**KIRKLEES METROPOLITAN COUNCIL
INVESTMENT & REGENERATION SERVICE**

DELEGATED DECISION TO DETERMINE PLANNING APPLICATIONS

Reference No:	2023/62/90945/E
Site Address:	adj, 9, Hyrst Gardens, Batley, WF17 7EH
Description:	Erection of detached dwelling
Recommending Officer:	Alice Downham

DECISION - REFUSE

PLAN 2 OF 3	
Scale	1:250@ A3
Plan Title	Tree Impact Plan
Site	Off Track Rd, Batley
Date	7.2.23
tree@treeplan.co.uk

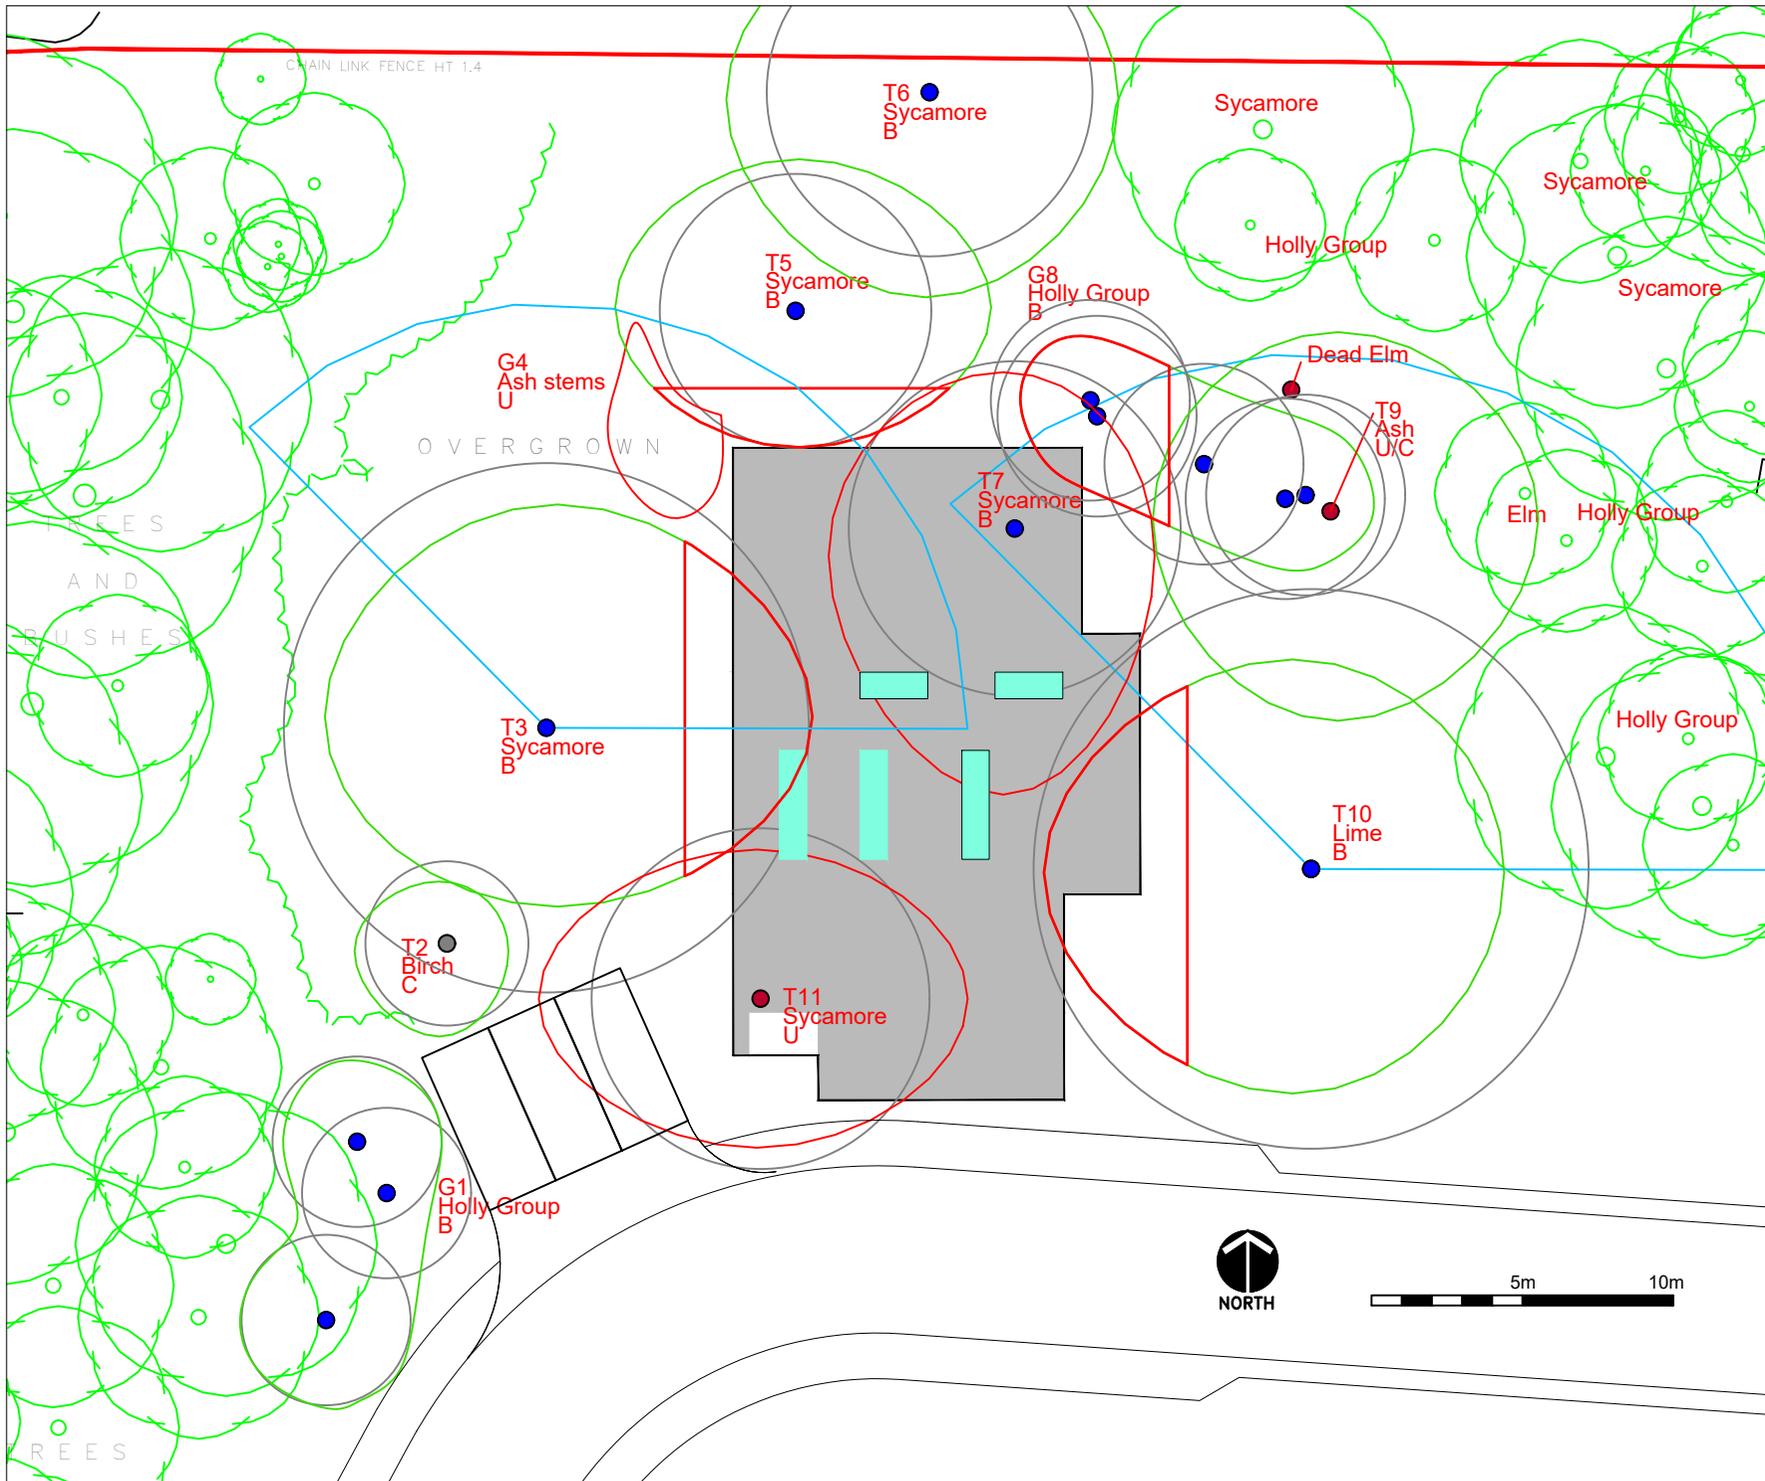
There are multiple trees subject to Tree Preservation Orders within the red line boundary of the site. As such, KC Trees officers were consulted on the application. Their response highlights that the proposals for a dwelling on this site would result in a significant impact on the important trees on this site. It is noted that trees have been removed as part of the existing surrounding residential development. The submitted Arboricultural Impact Assessment suggests the loss of three trees and cutting back of others is acceptable. However, the long-term effects of the adjacent trees to the proposed dwelling from nuisance and shade impacts would likely result in a significant pressure to prune or fell the trees. The loss of further trees on this site and the long-term impact of the proposed dwelling so close to retained trees is contrary to Policies LP24 and LP33 of the Kirklees Local Plan.

1. There are multiple trees subject to Tree Preservation Orders within the red line boundary of the site. The proposals for a dwelling on this site would result in a significant impact on the protected trees on this site. Trees have previously been removed as part of the existing surrounding residential development, and the loss of three trees and cutting back of others is proposed in the submitted Arboricultural Impact Assessment. However, the long-term effects of the adjacent trees to the proposed dwelling from nuisance and shade impacts would likely result in a significant pressure to prune or fell the trees. The loss of further trees on this site and the long-term threat of the proposed dwelling so close to retained trees is contrary to Policies LP24 and LP33 of the Kirklees Local Plan and guidance contained within Chapters 12 and 15 of the National Planning Policy Framework.
